Please ask for: Ms Iqraa Malik
Email: iqraa.malik@terraquest.co.uk
Telephone: 01212341390
Our Ref: A/63/21/HH
Your Ref:
Date: 8th April 2021

Application for Planning Permission for Works or Extension to a Dwelling

Development: Single storey side extension. This is a resubmission, with minor amendments, to approved application A/156/20/HH.
Location: 16 Woodlands Close Angmering BN16 4NA

SITE PLANS

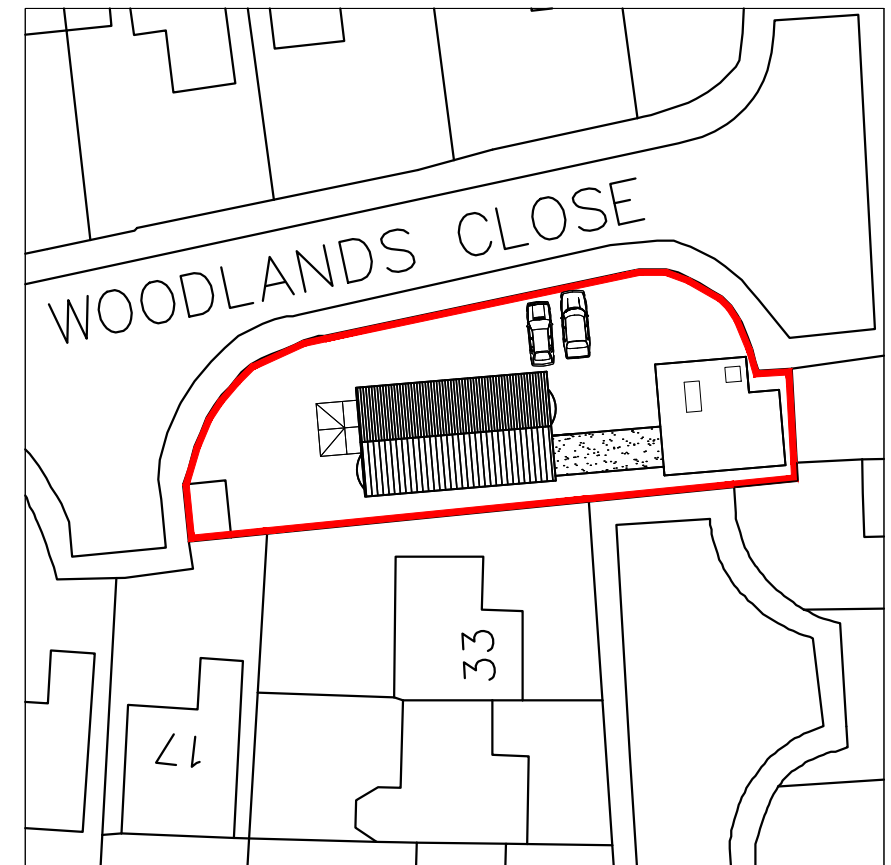
Dimensions: You are required to include dimensions on the block plan from the proposed extensions to all site boundaries.
